RE: **Lot 7 Block 1 Volcano Cliffs SAD 227**
6209 Papagayo NW
Grading and Drainage Plan
Engineers Stamp Date 9/25/17 (D10D003B26)

RE: **Lot 26 Block 6 Unit 22 Volcano Cliffs SAD 228**
6209 Papagayo NW
Grading and Drainage Plan
Engineers Stamp Date 9/25/17 (D10D003B26)

Based upon the information provided in your submittal received 9/26/17, this plan cannot be approved for Grading Permit until the following comments are addressed.

ENGINEER'S SEAL	6209 PAPAGAYO ROAD NW	DRAWN BY WCWJ
		DATE 9-22-17
9/25/17	GRADING AND DRAINAGE PLAN	21800-LAYOUT-9-22-17
DAVID SOULE P.E. #14522	 <div>Rio Grande Engineering 1606 CENTRAL AVENUE SE SUITE 201 ALBUQUERQUE, NM 87106 (505) 872-0899</div>	SHEET # —
		JOB # 21800

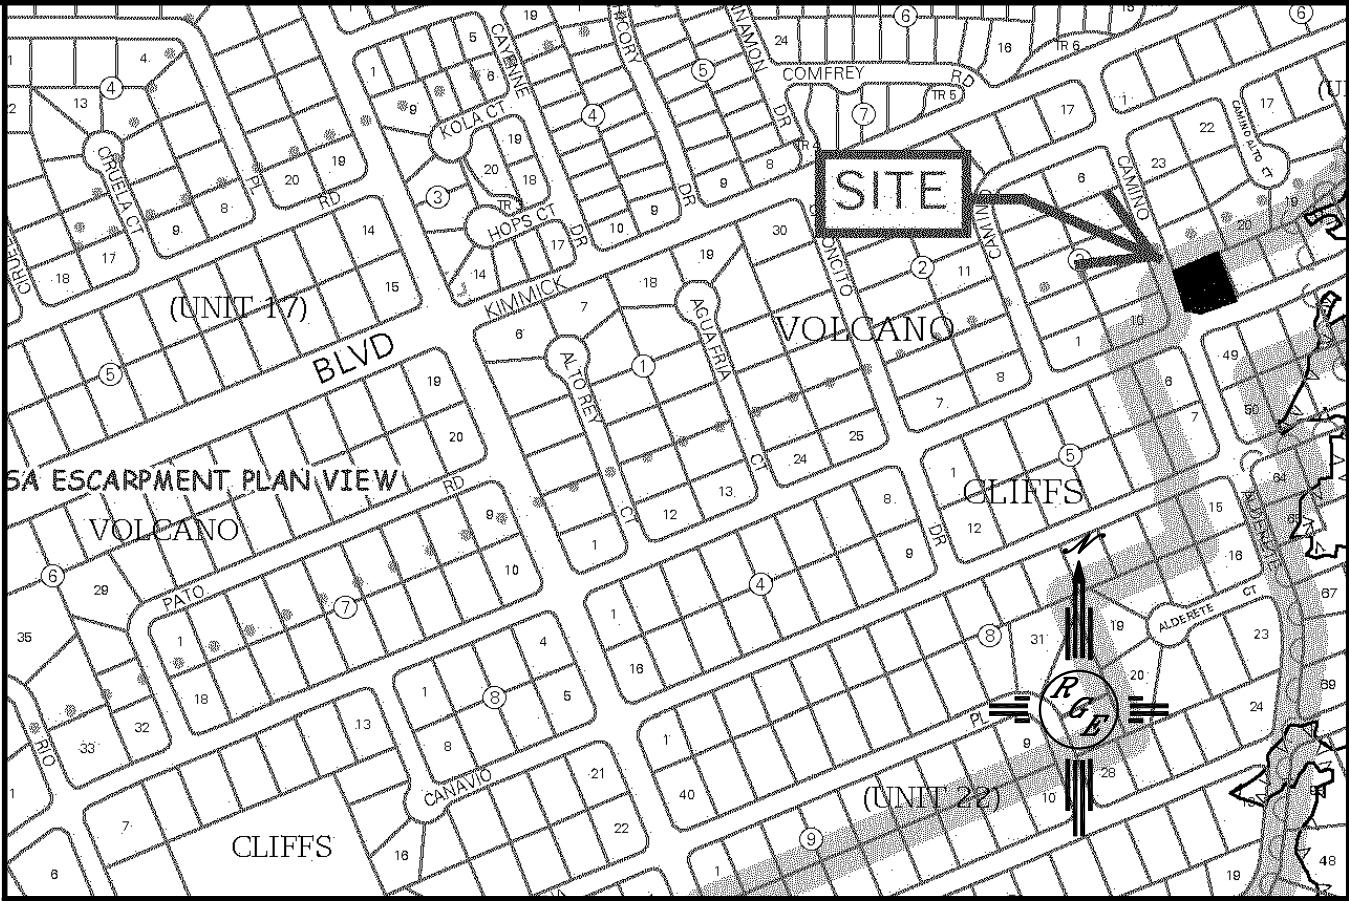
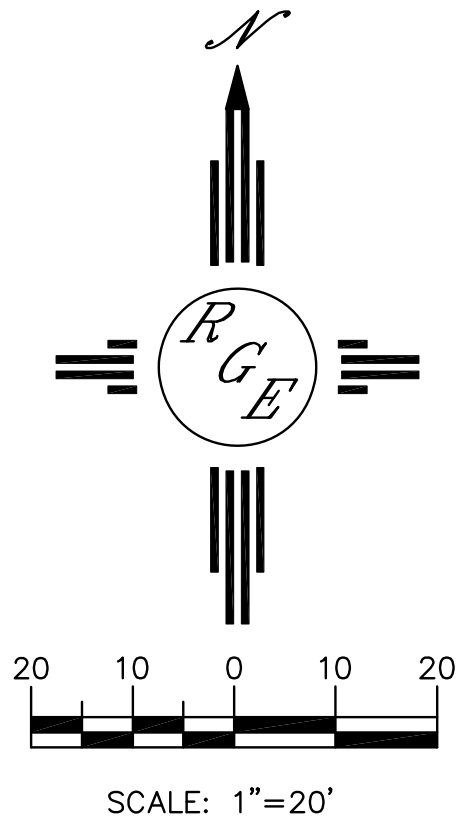
- Show the 7 foot P.U.E. in the North and East of the property.
- Provide size of openings and calculations required in future garden walls.
